## Application by Highways England for the A19 Downhill Lane Junction Scheme

### The Examining Authority's Written Questions and Requests for Information (ExQ1)

**Issued on 20 August 2019**

REVISED VERSION OF FIGURE 6.1 OF THE ES

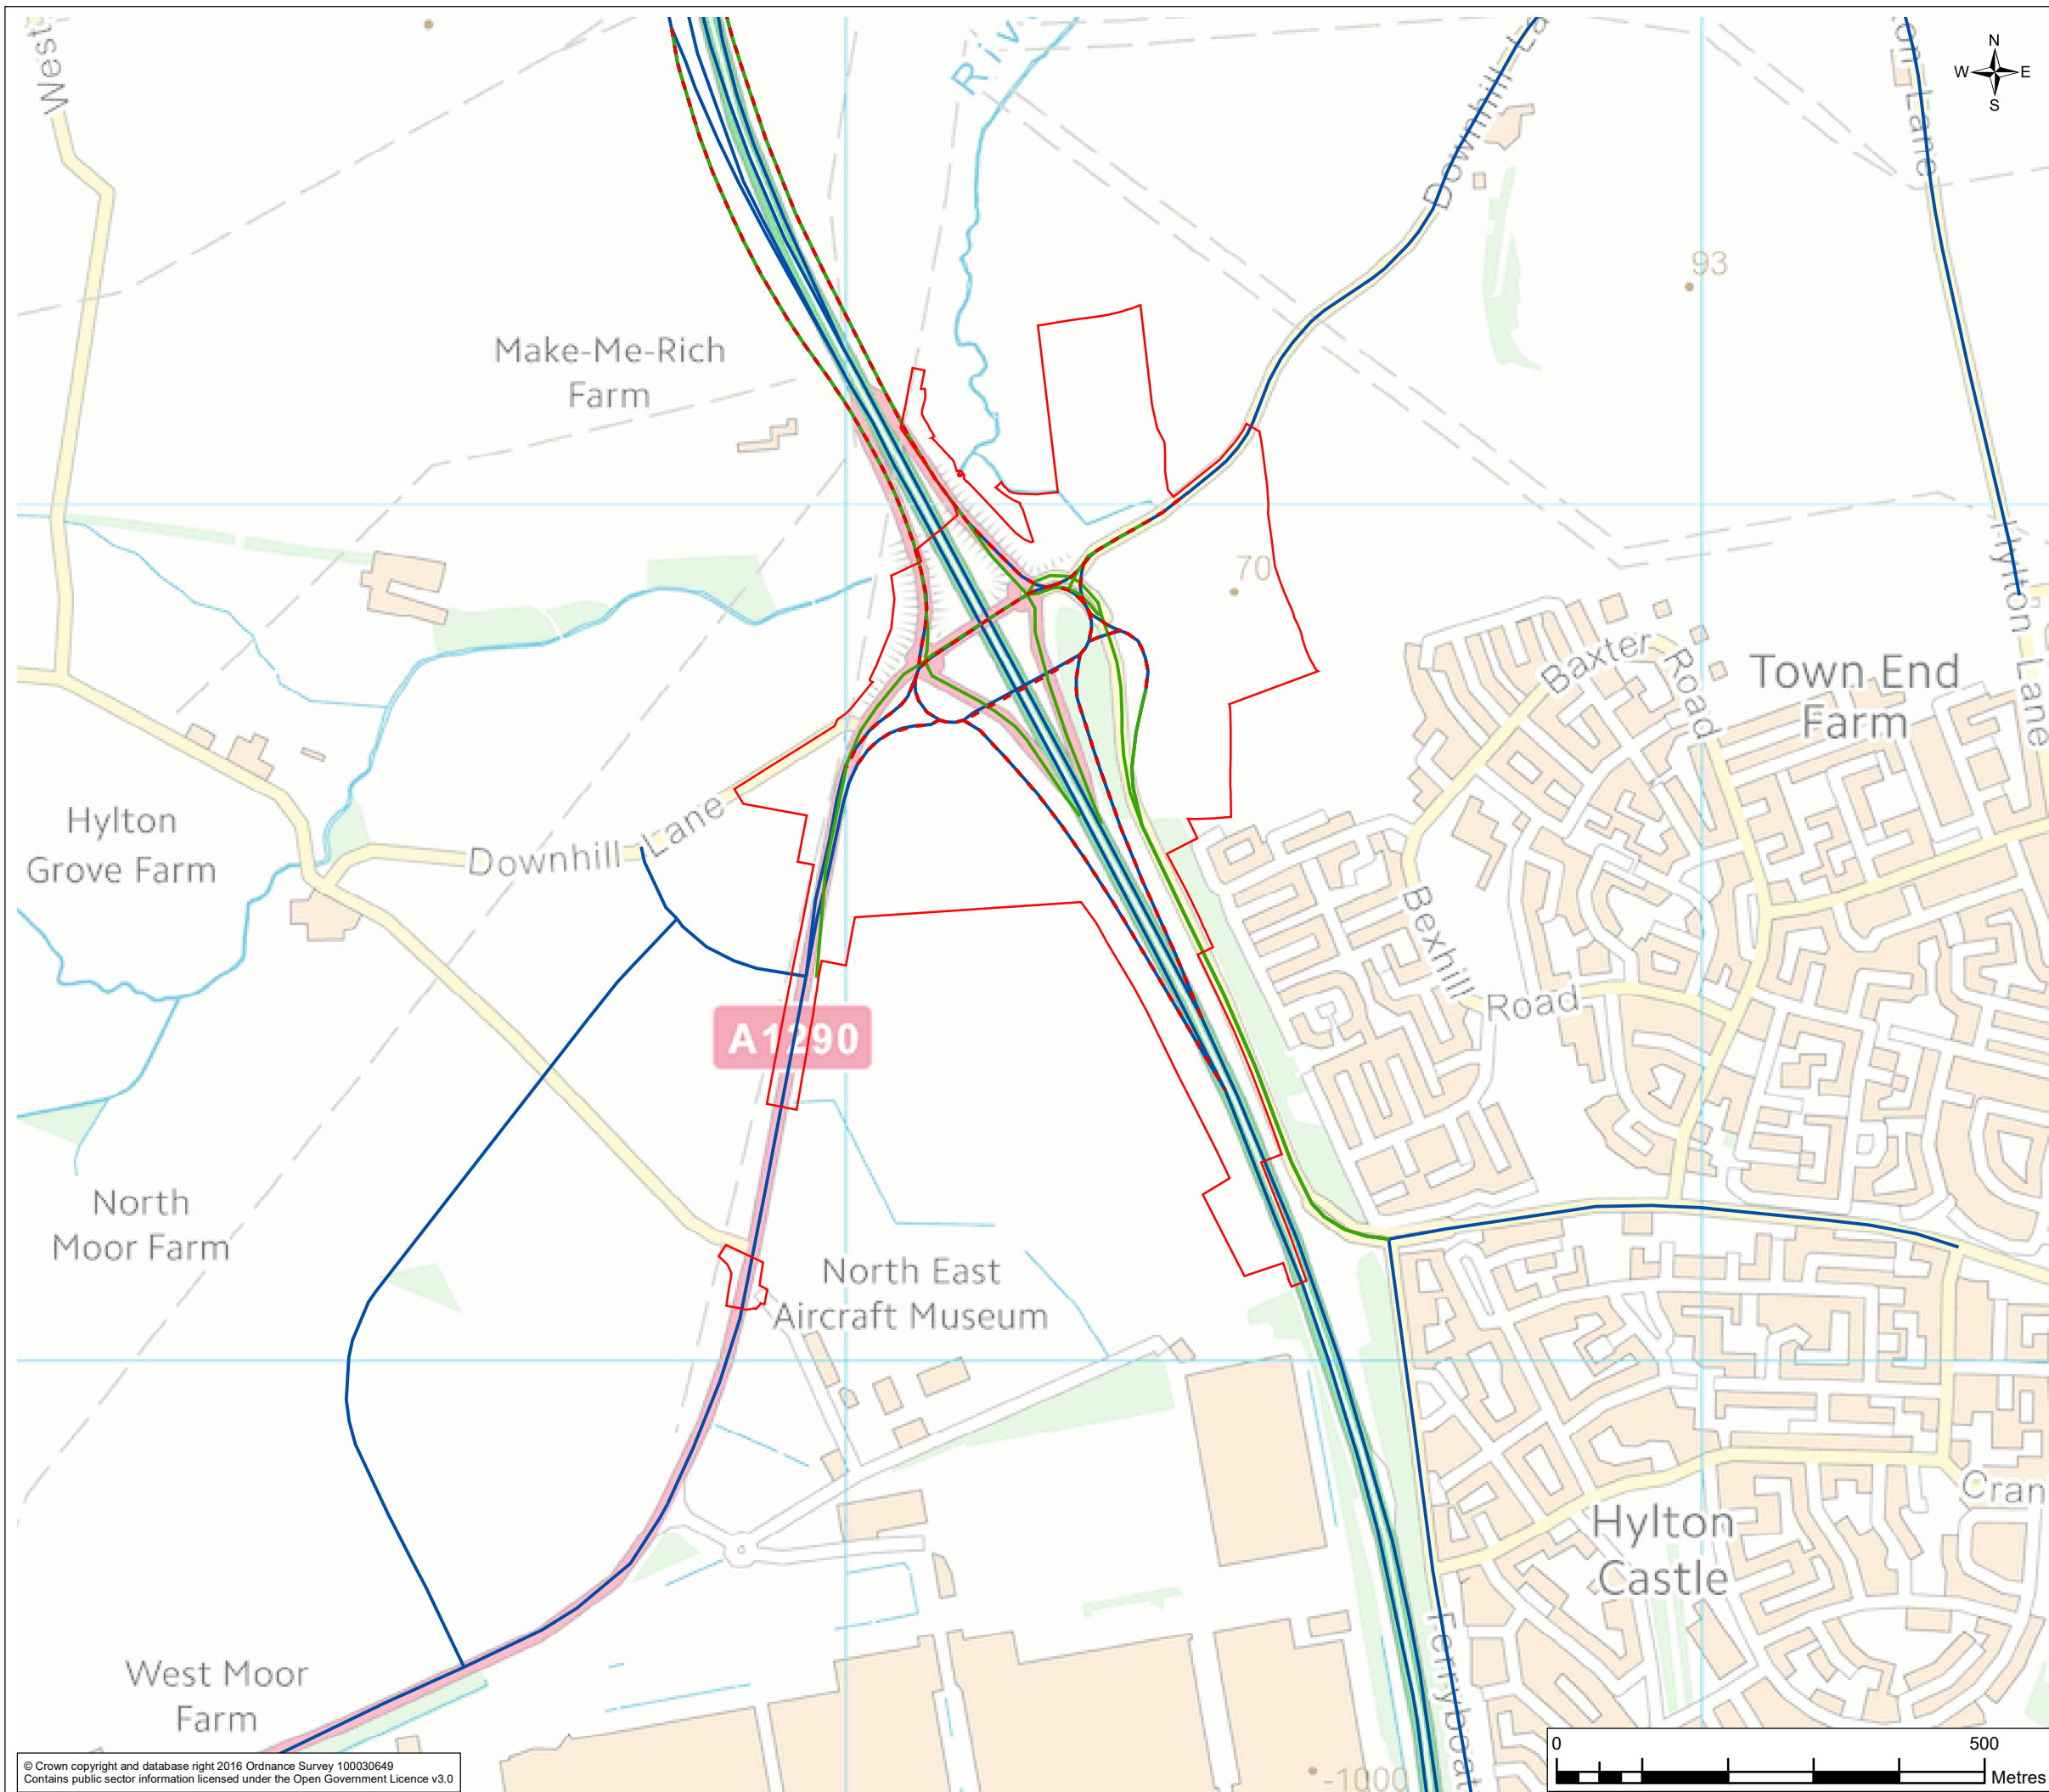
Ref No.	Respondent:	Question:
<b>2</b>	<b>Air Quality and Emissions</b>	
<b>Q1.2.1</b>	Applicant	<p>Paragraph 6.3.7 of the ES [APP-020] states that the study area for the assessment of air quality was defined by identifying all sensitive receptors 200m from the affected road network. Paragraph 6.3.9 refers to Figure 6.1 [APP-023] indicating that it illustrates the air quality study area and constraints and that the study area covers the Downhill Lane junction, sections of the A19 and sections of the A1290. Figure 6.1 shows the modelled road network whilst Figure 6.2 and subsequent figures show the position of 10 receptors with the highest concentrations within Table 6.5-a in Appendix 6.5 [APP-33] identifying all 55 receptors.</p> <p>The Applicant is asked:</p> <ul style="list-style-type: none"> <li>• to clarify how the 55 receptors were identified and to show them on a plan to enable the study area boundary to be mapped;</li> <li>• to clarify how the modelled road network was identified and whether this is different from affected roads;</li> <li>• with respect to Figure 6.1 to show the affected road links which the key indicates are shown as red or green in colour but do not appear to be shown other than a short stretch of Washington Road - is this because there would be no affected roads subject to an increase in traffic?; and</li> <li>• to explain why the modelled road network includes only Washington Road and Ferryboat Lane within the quadrant to the south east of the application site.</li> </ul>
